**Town and Country Planning Act 1990
Application for Permission to Develop Land**

Response from Pollution & Noise Control

PNC Reference No:	WK/201817437
Name of Planning Officer dealing with the matter:	John Ritchie
Application Number:	2018/92802
Proposed Development:	Discharge condition 17 (electrical charging point) on previous permission 2015/93824 for outline application for erection of 56 dwellings and care home with associated car parking
Location:	Former Midlothian Garage, New Mill Road, Holmfirth, HD9 7LN
Date Required By Planning:	20 Sep 2018

704-EVF-01

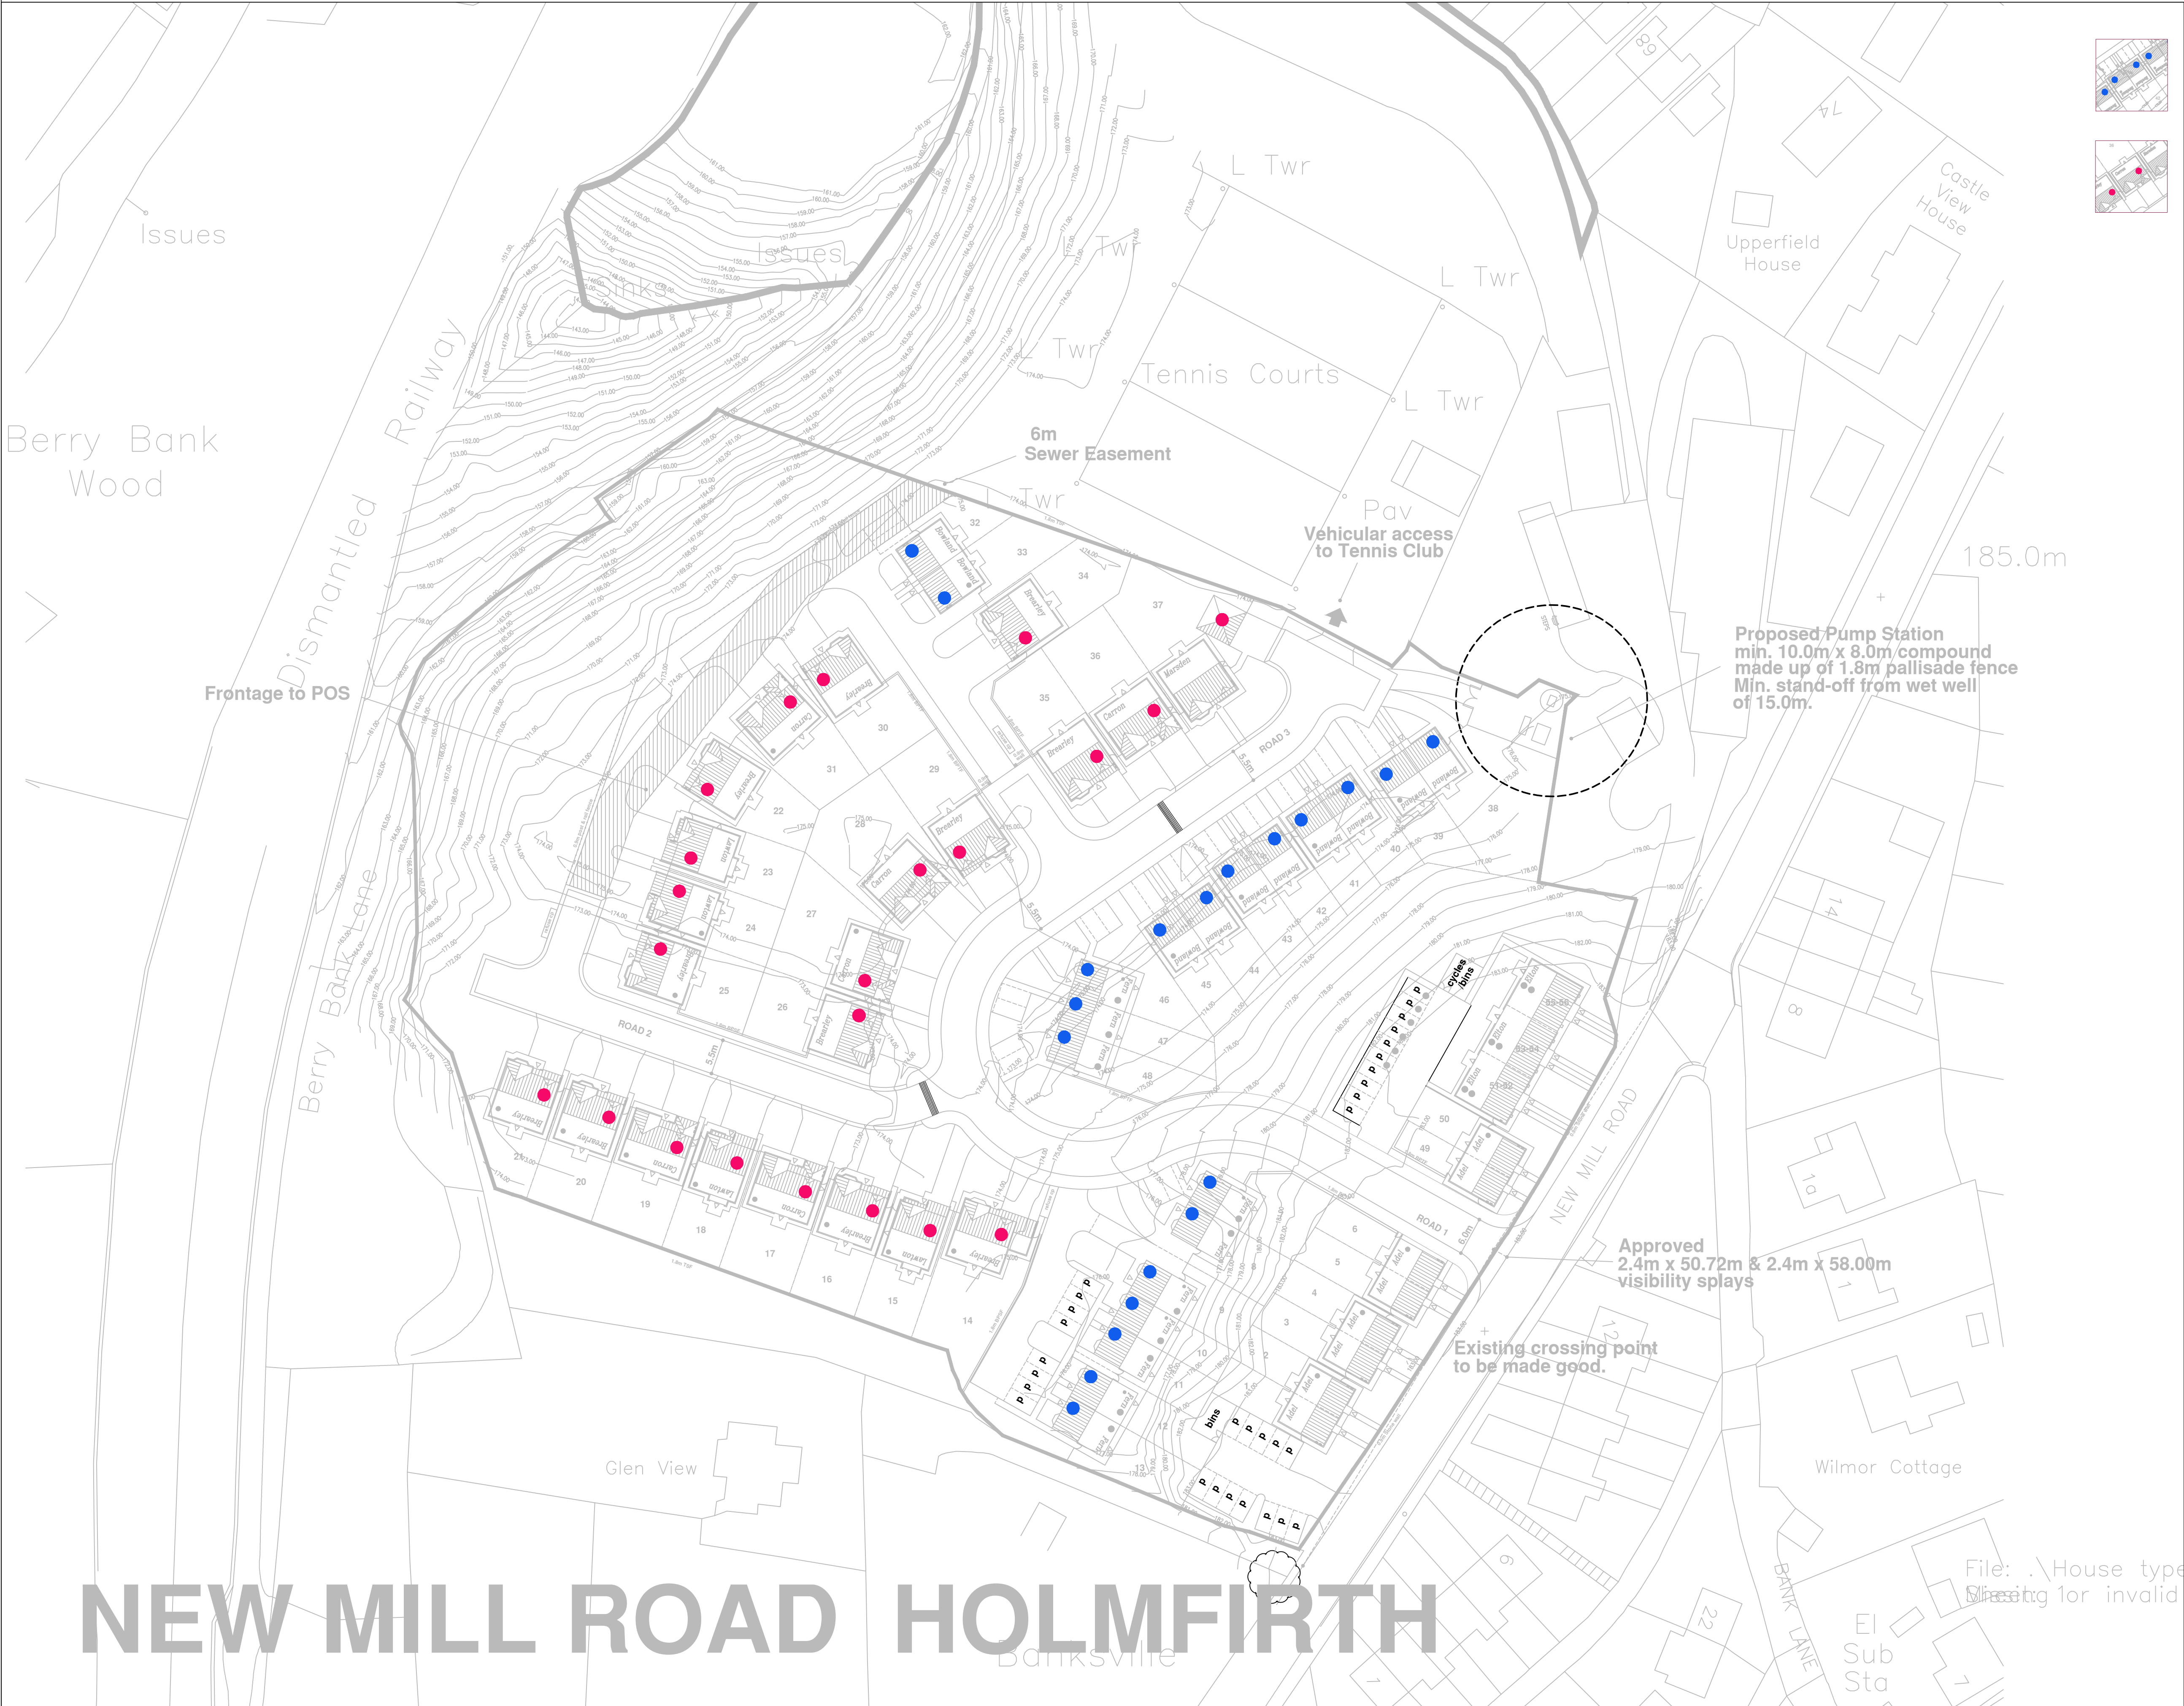
COMMENTS
Condition 17 requires the applicant to provide details of the proposed electric vehicle charging points scheme for approval. The approved scheme is then to be implemented and retained. The applicant has submitted a plan by Picea Design dated 23 Aug 2018 (Dwg No. 704-EVF-01) The plan shows which plots will be provided with either a 13 Amp weather proof external socket or a 13 Amp internal socket in garage (mode 1 compliant). It also shows a number of plots with parking but with no proposals for charging points. The proposals are unsatisfactory. An electric vehicle charging point is required for every dwelling with a dedicated parking space. In addition, 1 charging point is required for every 10 unallocated parking spaces. 13A sockets are standard in every property and a condition would not be required if these were considered to be suitable. The charging points need to meet the minimum requirements specified in "Electric Vehicle Homecharge Scheme minimum technical specification" by Office for Low Emission Vehicles. Broadly speaking a Mode 3 charger with a Type 2 Socket and electrical supply capable of providing a constant current of 16A would be satisfactory.

For the reasons detailed above I consider that the information submitted is insufficient for the requirements of Condition 17
